Consultation Response from KC, Conservation & Design
2022/93964 17-33a, John William Street, Huddersfield, HD1 1BR
Listed Building consent for reinstatement, refurbishment and repair of 6no shops and signage [within a Conservation Area]
Date Responded: 23.1.2023
Responding Officer: Sue Brooks
Responding Ref: HUD 1/687

DRG:
PROPOSED STREET SCENE ELEVATION

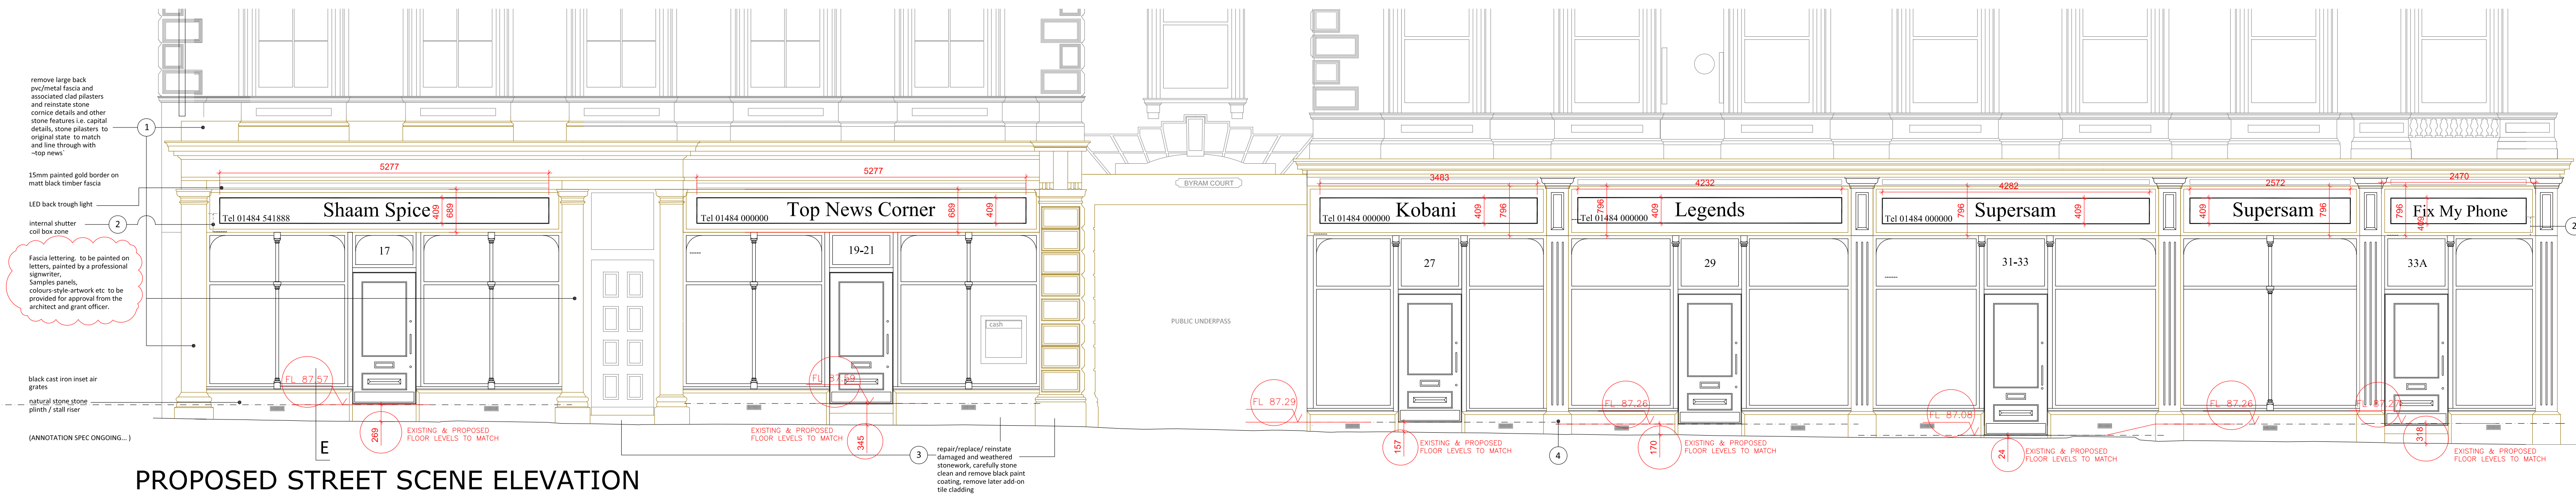
- Details of stone cleaning and paint removal methods shall be submitted for approval.
- Gold border – we would suggest that this is gilded rather than painted.
- Fascia lettering. We would accept painted on letters, painted by a professional signwriter, rather than fret cut lettering.
- Brass letter plates and ironmongery – we would suggest that ironmongery is not lacquered as this will become scratched.
- If black glass is proposed above transom level to hide bulkheads, we would recommend black glass rather than applied film.
- Stall risers and stone repairs must match existing in terms of stone type, constituents, colour, aggregate size, finish and bedding. Joints for repairs must be tight, and in lime mortar.
- We would recommend that level access is specified where possible, with amendments made prior to determination or by condition.
